PROJECT: New Portland Service Building
Five (5) Foot East Truck Bay Building Addition
Punch List
Portland, Maine
DATE: Thursday, December 29, 2011

PUNCH LIST ITEMS

NEW TRIM DETAIL @ EXISTING WINDOWS
 SCALE: 3" = 7'-0"

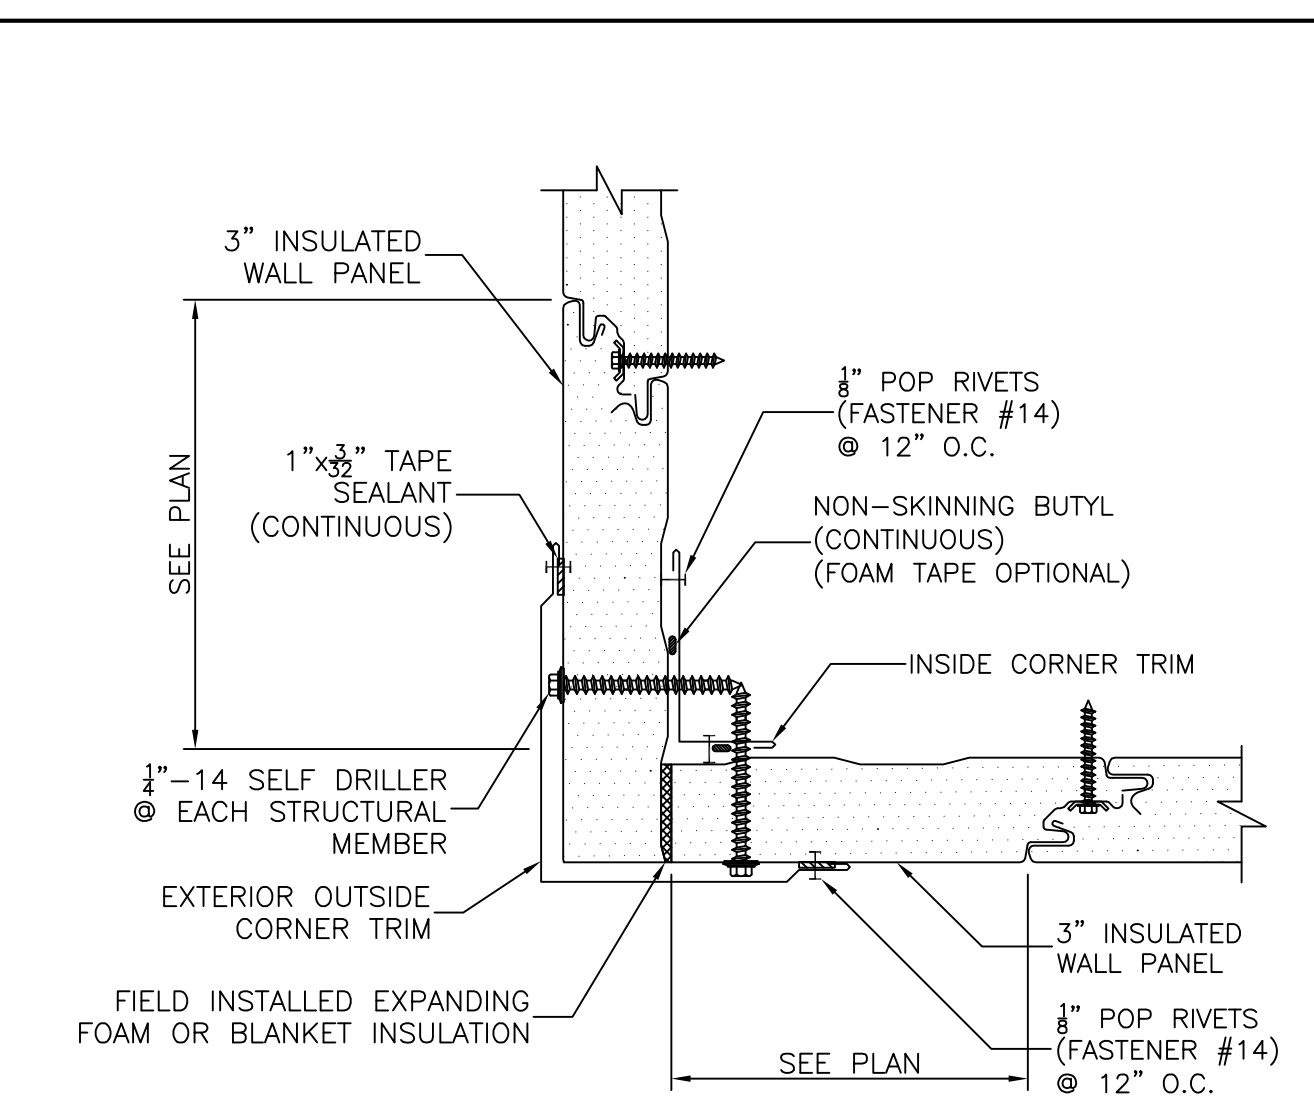
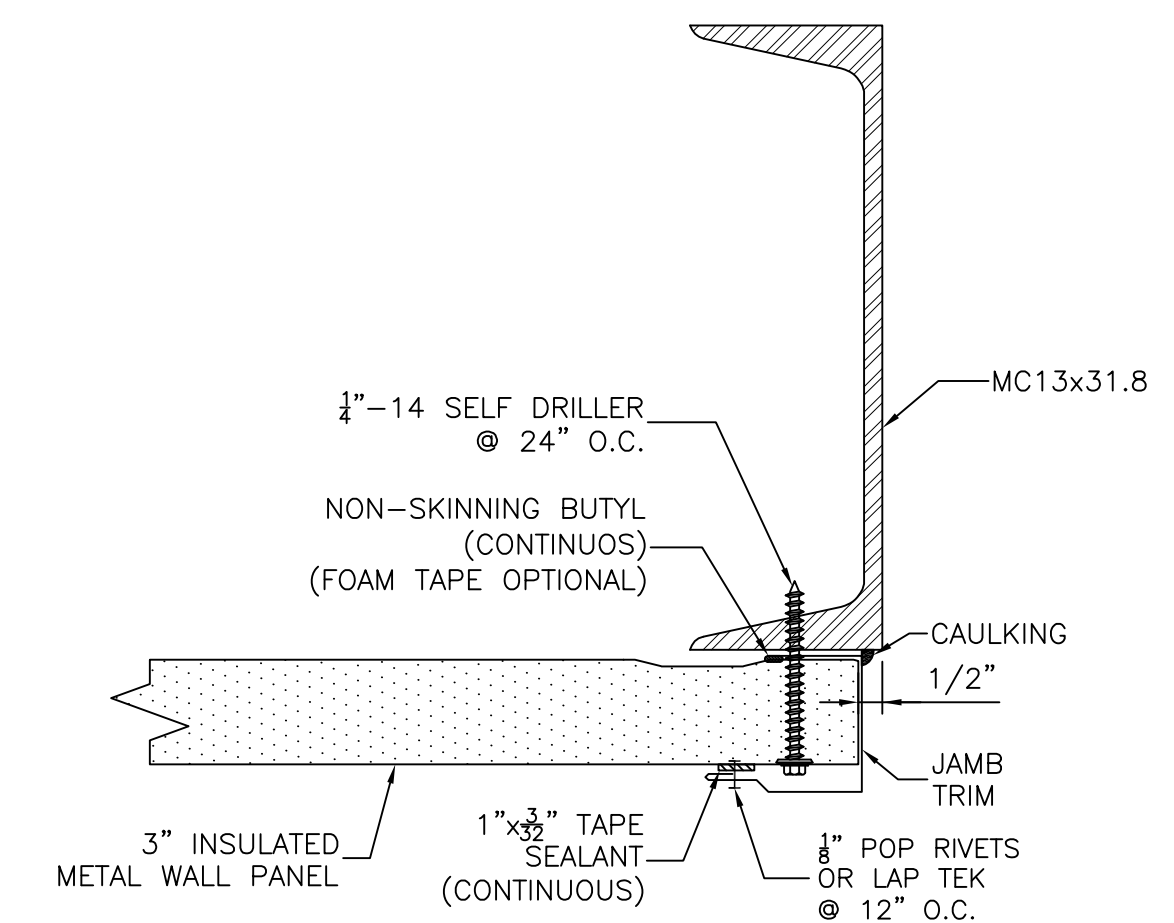
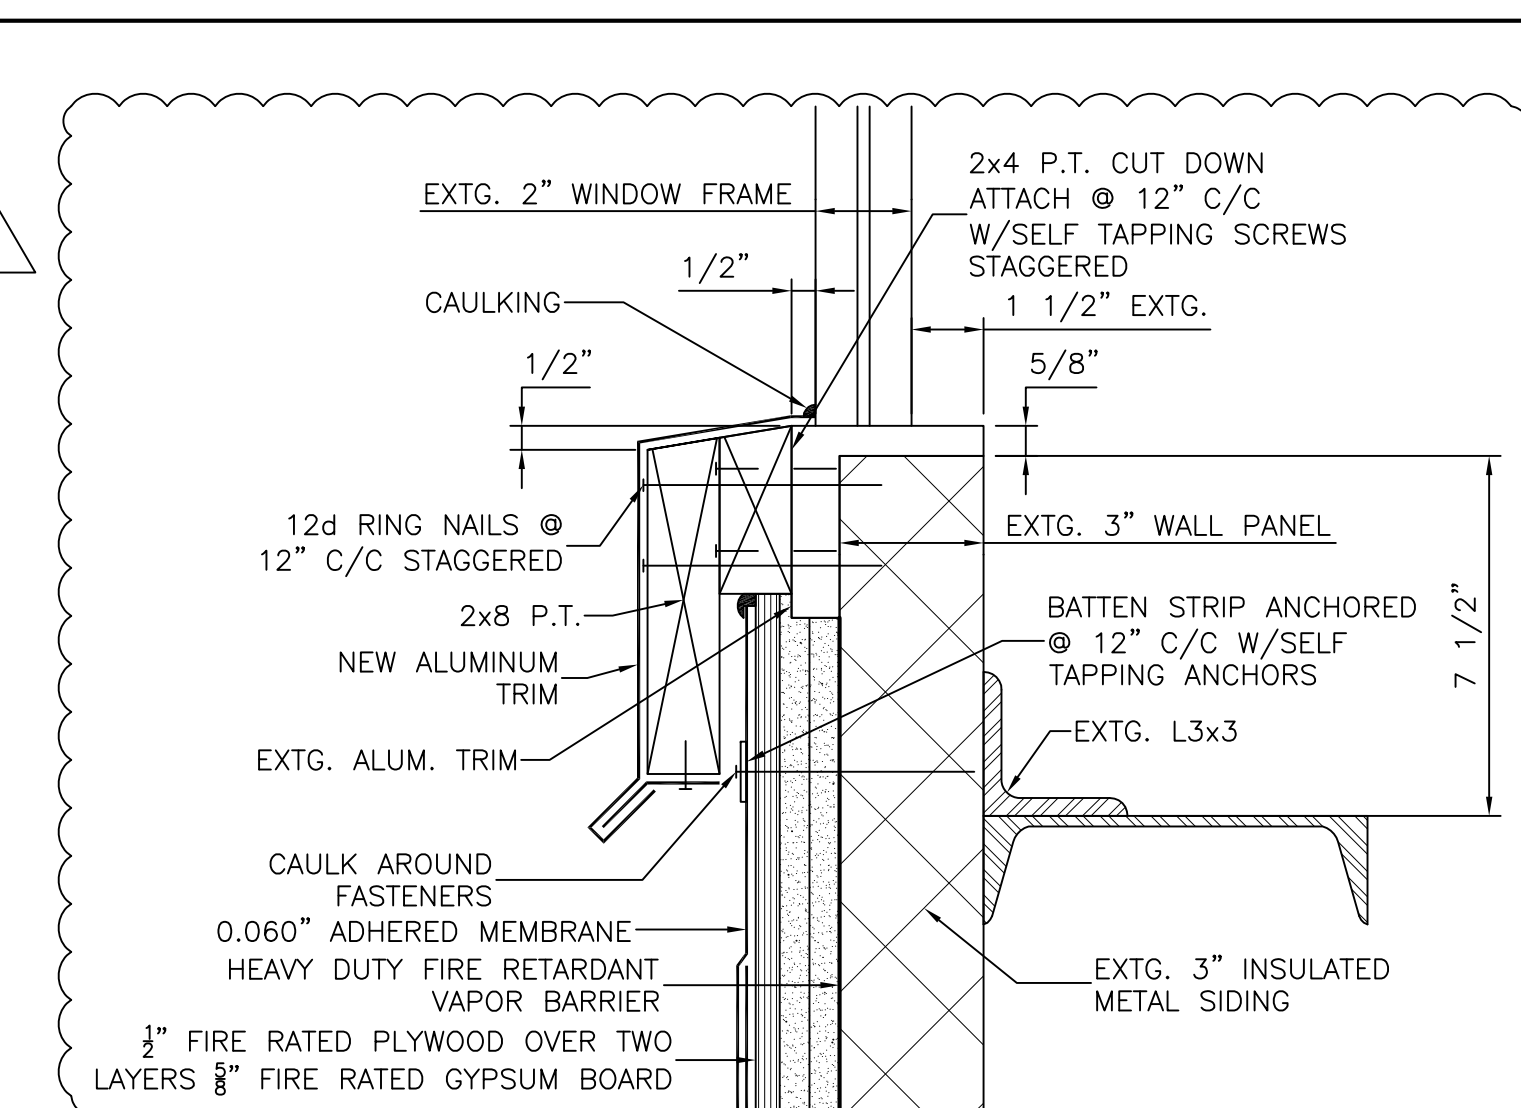
3. A leak was reported in the middle of overhead door #6. SECS's original design detail was changed by SMR roofers. The SMR detail is a good detail; however, it did not address the vertical seams that extend up onto the horizontal portion of the existing window sills. Also the existing window sills did not get recaulked as shown on the original detail. H.E. Callahan will need to get a detail to seal the open vertical/horizontal seams and recaulk the horizontal window seam. With the cold weather it may not be possible to do a permanent fix. SECS recommends as a minimum filling the open voids with RV sealant to get through the winter and prevent any damage to the new sheetrock. A copy of the original detail sketch is attached and photos showing the open vertical joints in the existing window trim.
